East Park Energy

Environmental Statement

Appendix 4-3 EIA Scoping Opinion Response Matrix

September 2025

© Crown copyright and database rights  
2025 Ordnance Survey AC0000808122

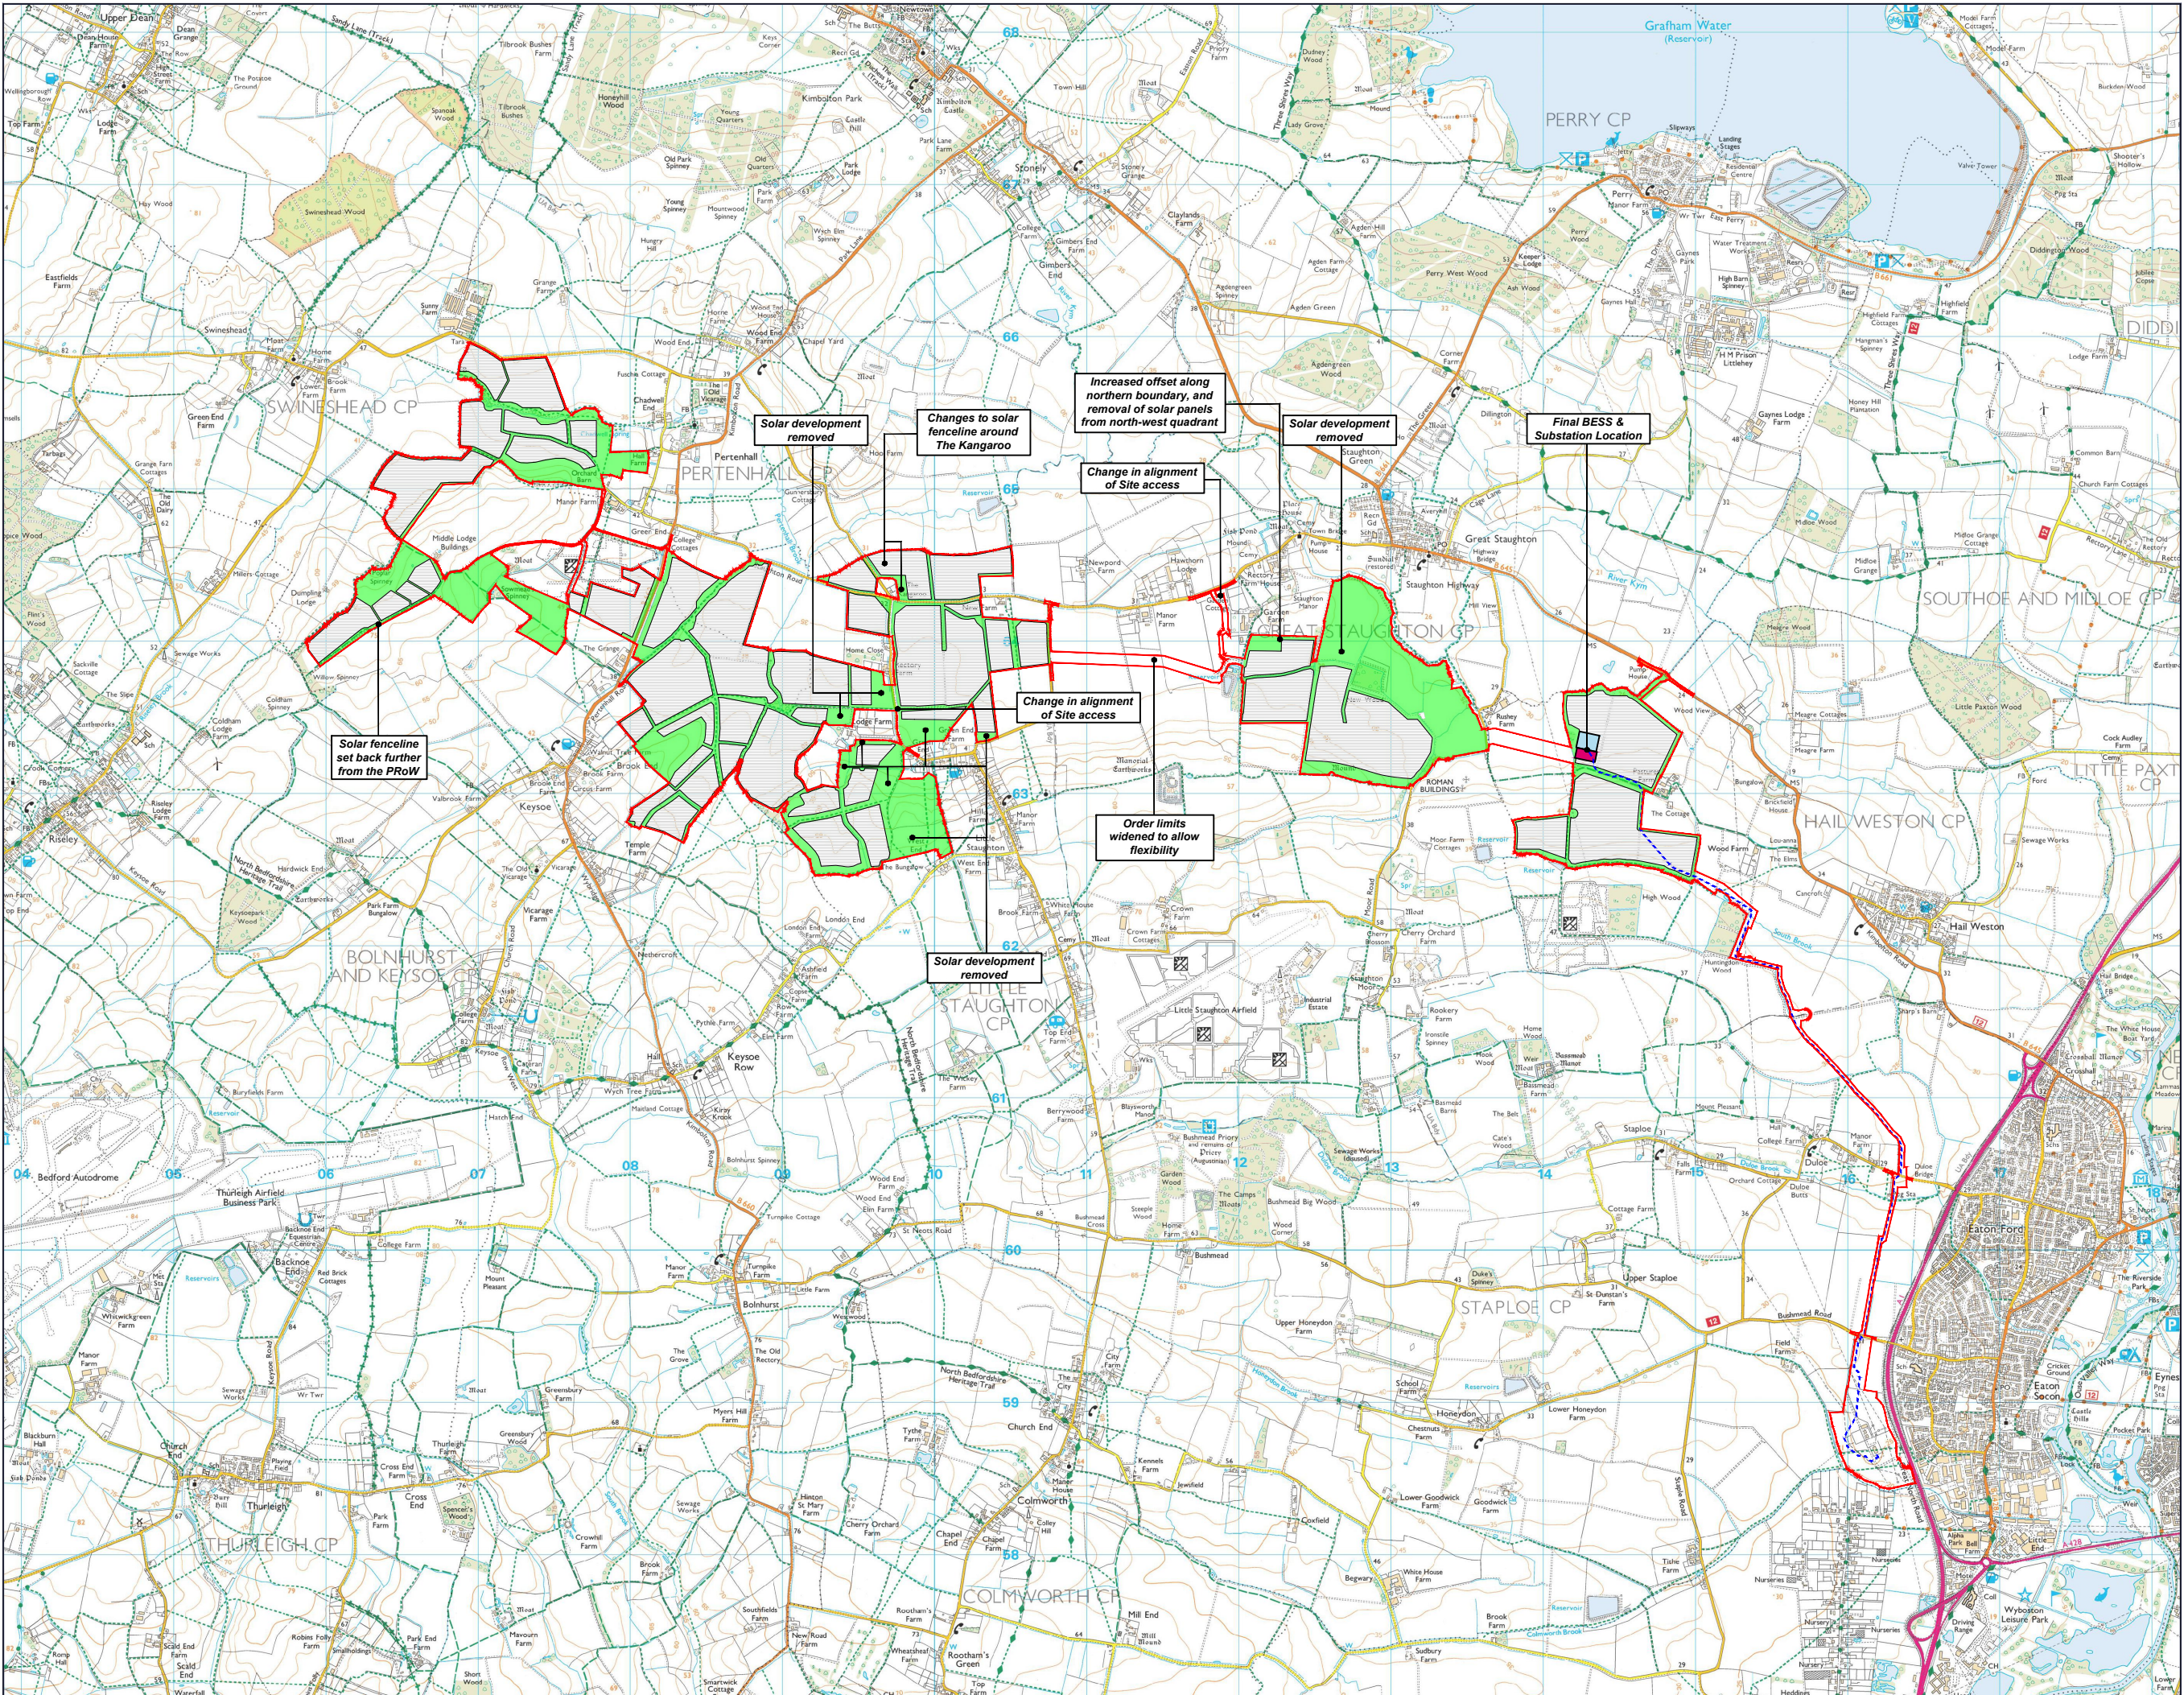
2.2.6	<p>Scoping table</p> <p>The Inspectorate recommends the use of a table in the ES to set out key changes in parameters/ options of the Proposed Development presented in the Scoping Report to those presented in the ES. It is also recommended that a table demonstrating how the matters raised in the Scoping Opinion have been addressed in the ES and/ or associated documents is provided.</p>	<p>This document sets out how the Applicant has responded to the matters raised by the Planning Inspectorate in Sections 2 and 3 of ES Vol 2 Appendix 4-2: EIA Scoping Opinion [EN010141/DR/6.2].</p> <p>ES Vol 1 Chapter 3: Alternatives and Design Evolution [EN010141/DR/6.1] and ES Vol 3 Figures 3-1 to 3-3 [EN010141/DR/6.3] describe the changes made to the Scheme since EIA scoping.</p>

Figure 2-5 Indicative Construction Access and Compounds (Rev P01)

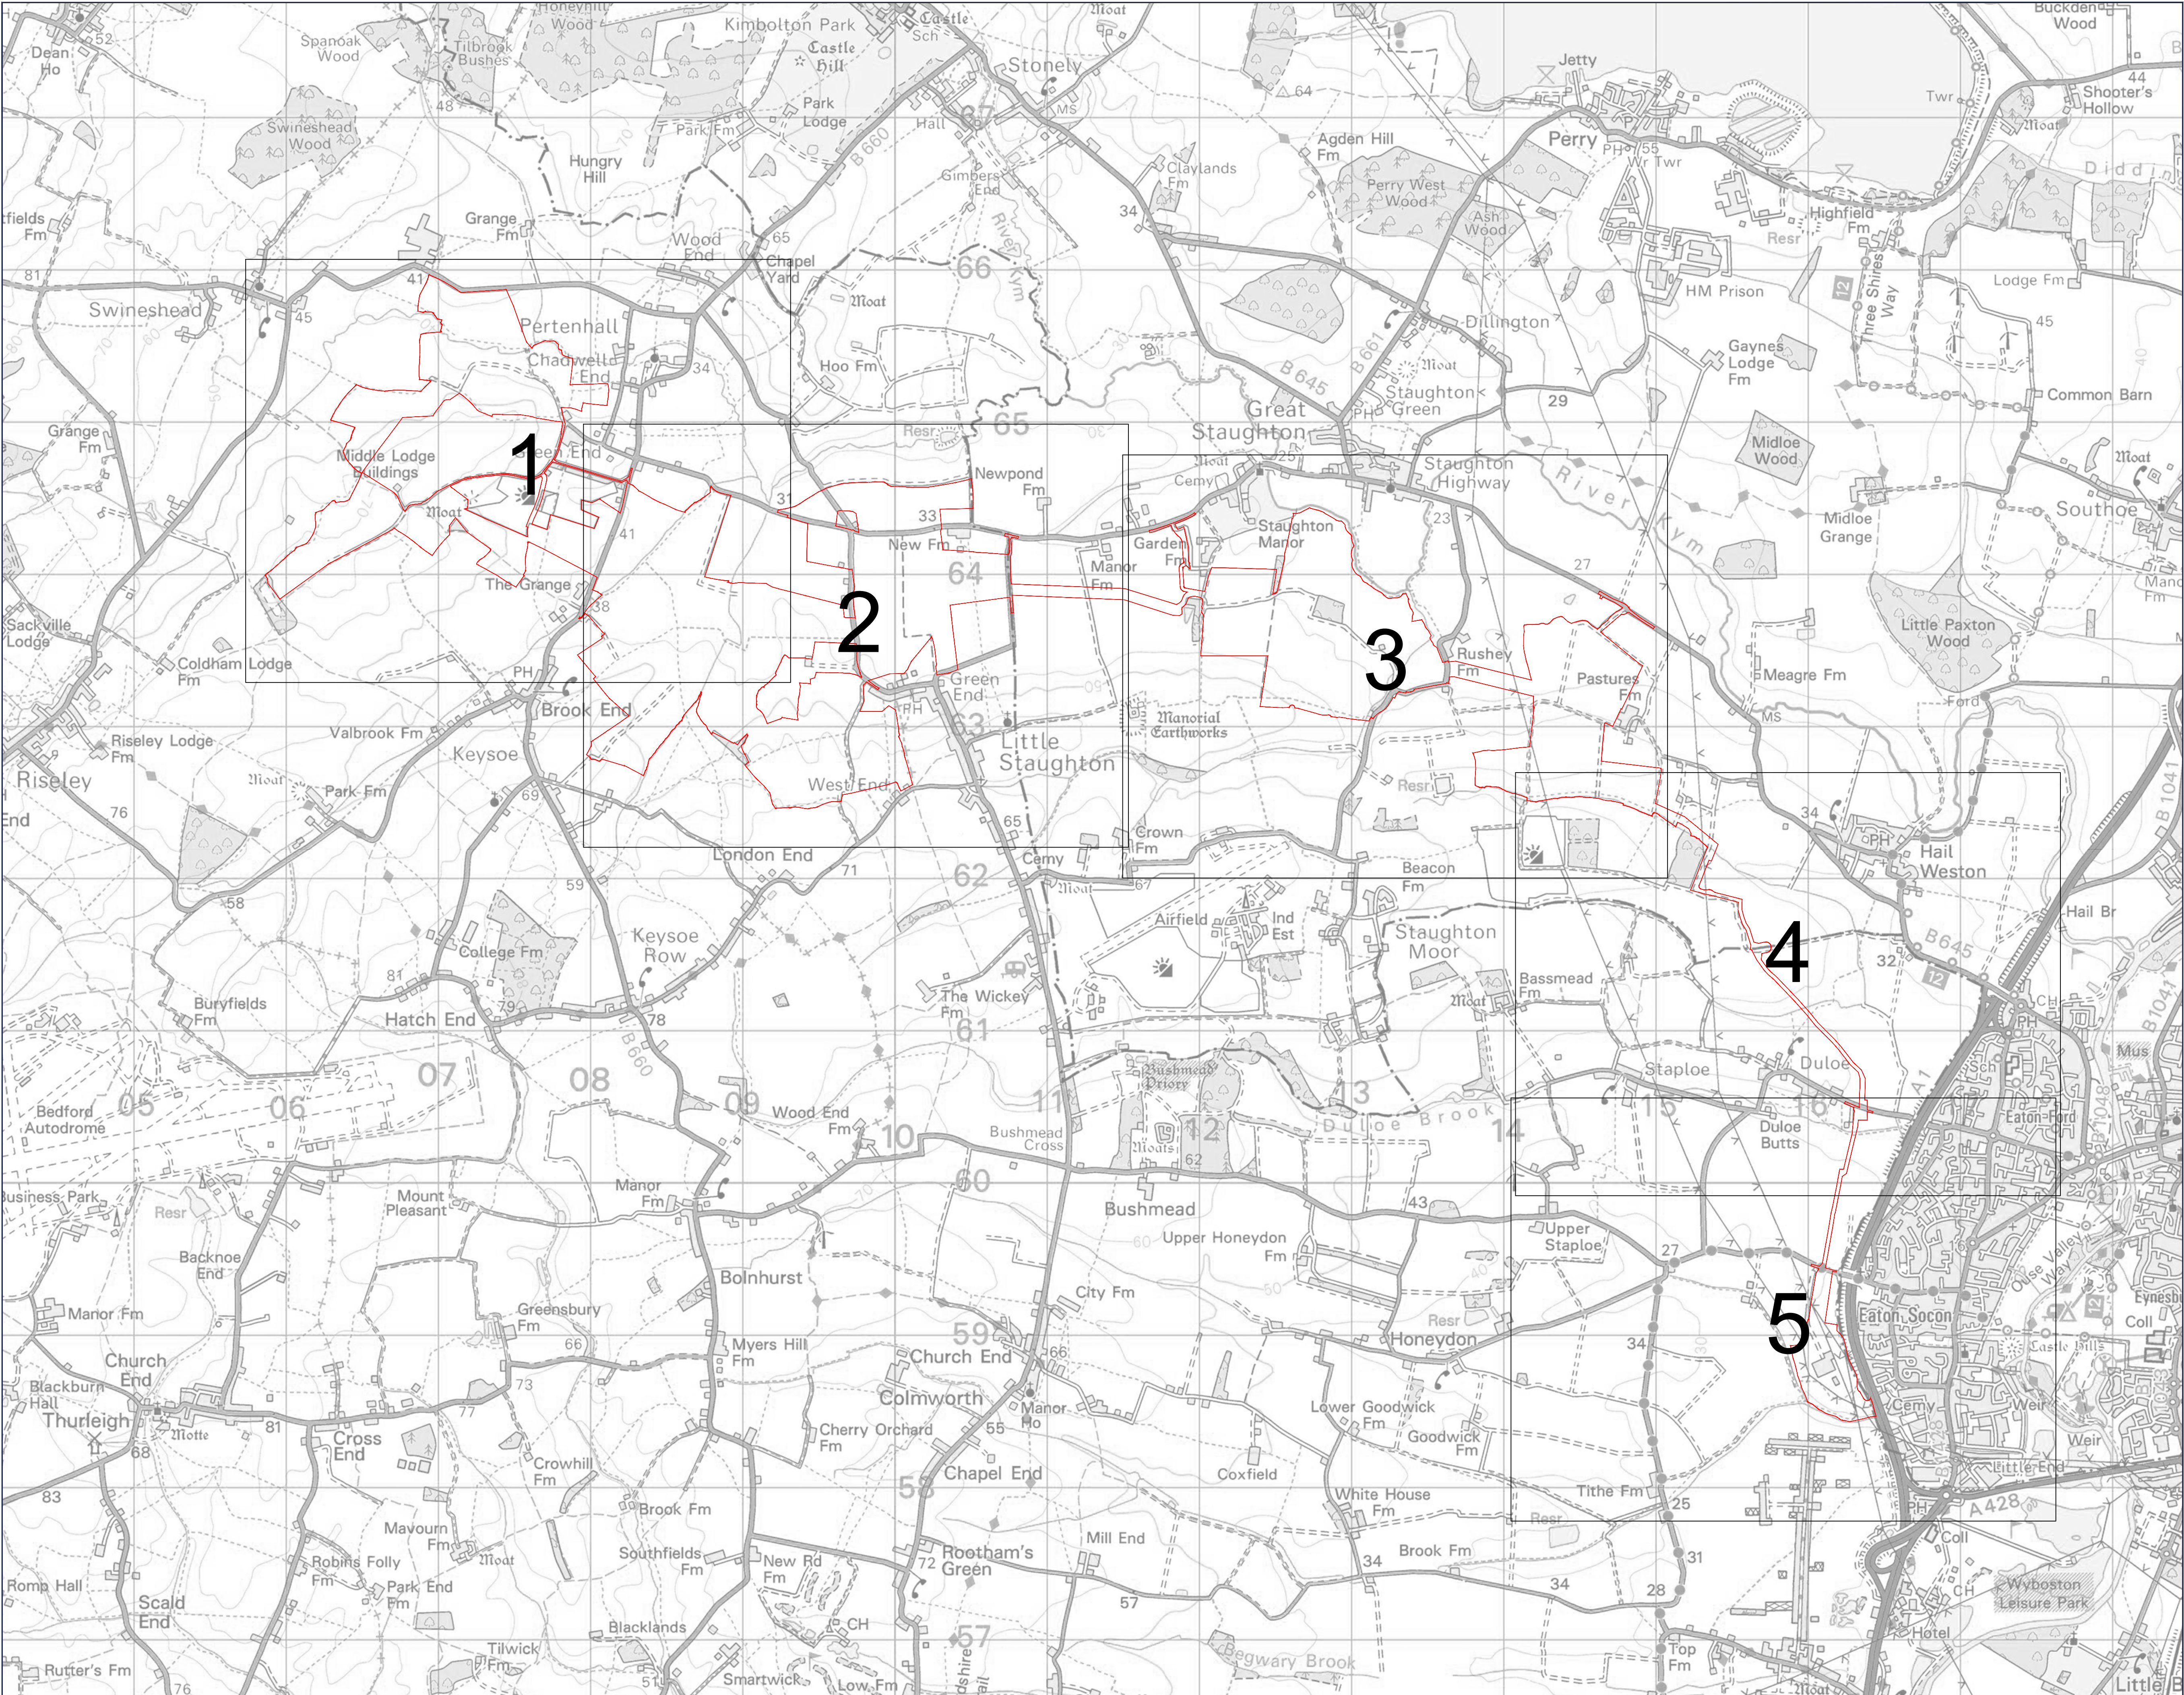
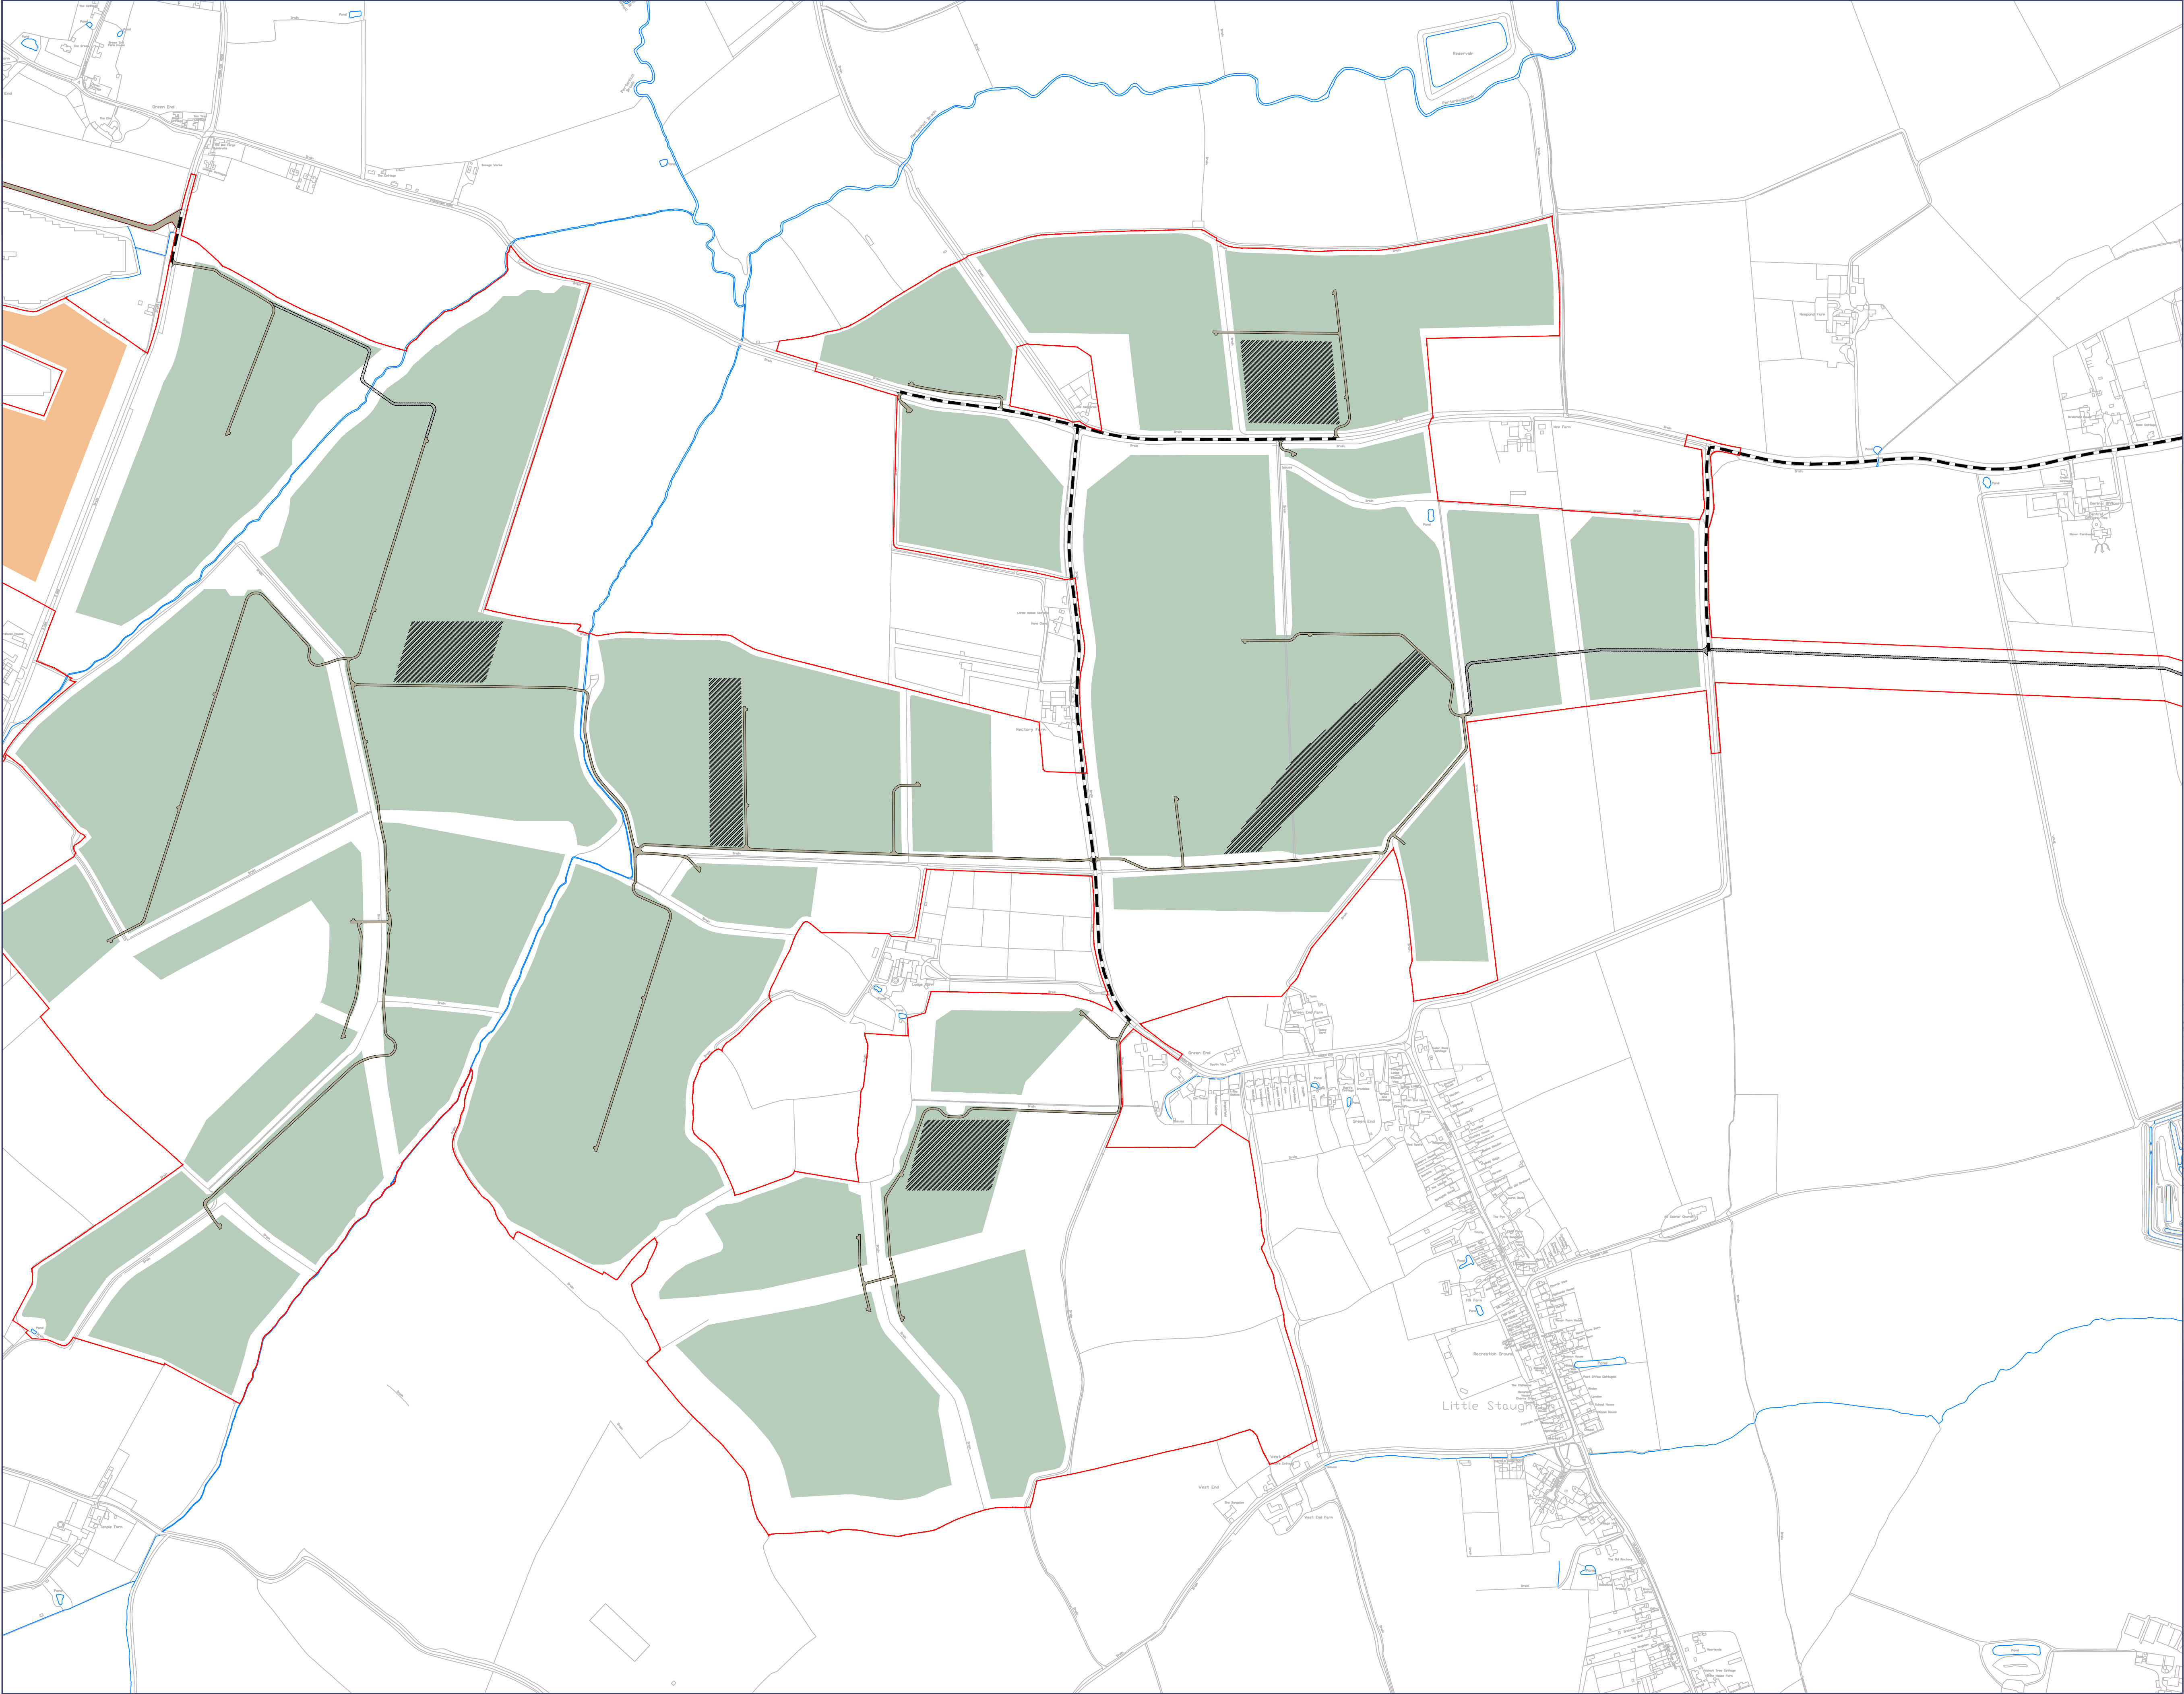
2.1.4	<p>Construction compounds</p> <p>The Scoping Report states that the Proposed Development would require one or more temporary construction compound(s) within the site, however, the exact location is yet to be determined. To ensure a robust assessment of likely significant effects (LSE), the ES should provide details regarding the number, location and dimensions of construction compounds.</p>	<p>The location of the temporary construction and decommissioning compounds are shown on ES Vol 3 Figure 2-5: Indicative Construction Access and Compounds, and secured by the limits of deviation of Work No. 7 as shown on the Works Plan [EN010141/DR/2.3].</p>
